WEST SUSSEX COUNTY COUNCIL CONSULTATION

TO:	Arun District Council FAO: Raymond Cole
FROM:	Stephen Gee WSCC - Highways Authority
DATE:	24 March 2020
LOCATION:	Ford Airfield Market West Sussex BN18 0FL
SUBJECT:	F/5/20/PL Reconfiguration of Ford Market, including revised market access, hardstanding for replacement vehicular parking and associated infrastructure, landscape, ancillary and site preparation works.
DATE OF SITE VISIT:	n/a
RECOMMENDATION:	No Objection
S106 CONTRIBUTION TOTAL:	n/a

FIGURE 5: MARKET ACCESS ARRANGEMENTS

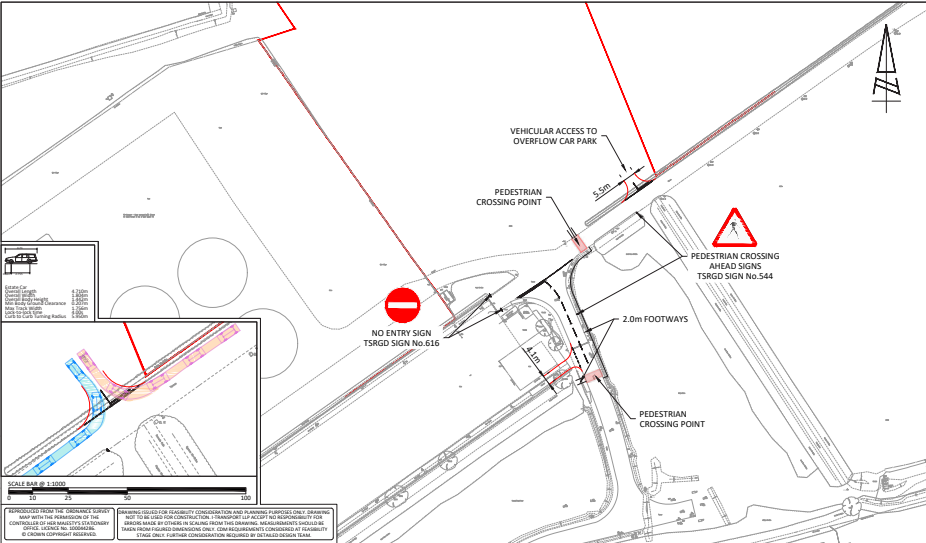
The Market would now be accessed from the existing eastern access onto Ford Road as shown on drawing ref ITB13091-GA-021 which benefits from a Ghost Island right hand turn into the site.

The site masterplan shows a link that will compromise a 2m wide gated access which will be closed when the market is not in operation and a 3.7m wide gated access with removeable bollard for emergency access (and site maintenance)

Details required on the pedestrian and emergency access which is to be provided prior to the closure of the eastern access.
